RE: Harnett County Land Use Application 06-5-15149

An Environmental Health Specialist from the Harnett County Health Department attempted to evaluate your property for the purpose of issuing an Improvement Permit. This individual was unable to evaluate your property for one or more of the following reasons.

**JASON PRICE CONST. INC.  
THE GRANT W/SUNROOM  
LOT #6 LAUREL VALLEY  
SCALE: 1"=40'**

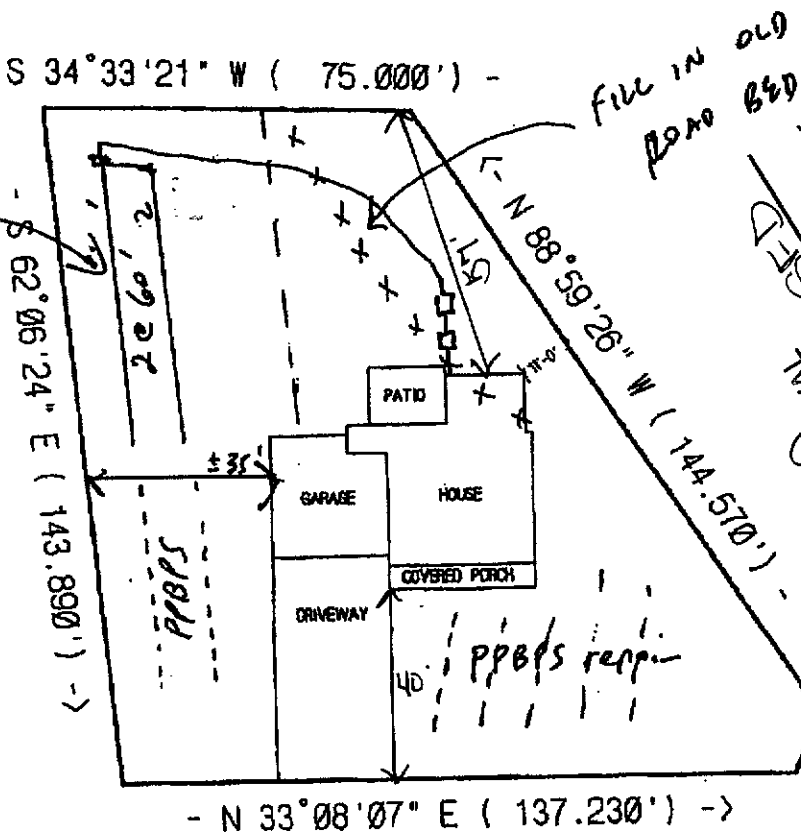
- 1. Property lines/corners not marked or labeled
- 2. House corners not marked or labeled
- 3. Directions not clear to property
- 4. Property needs brush or vegetation removed
- 5. Backhoe pits required
- 6. Other *Please move house as shown on attached sheet. Resubmit new plot plan to Central Permitting*
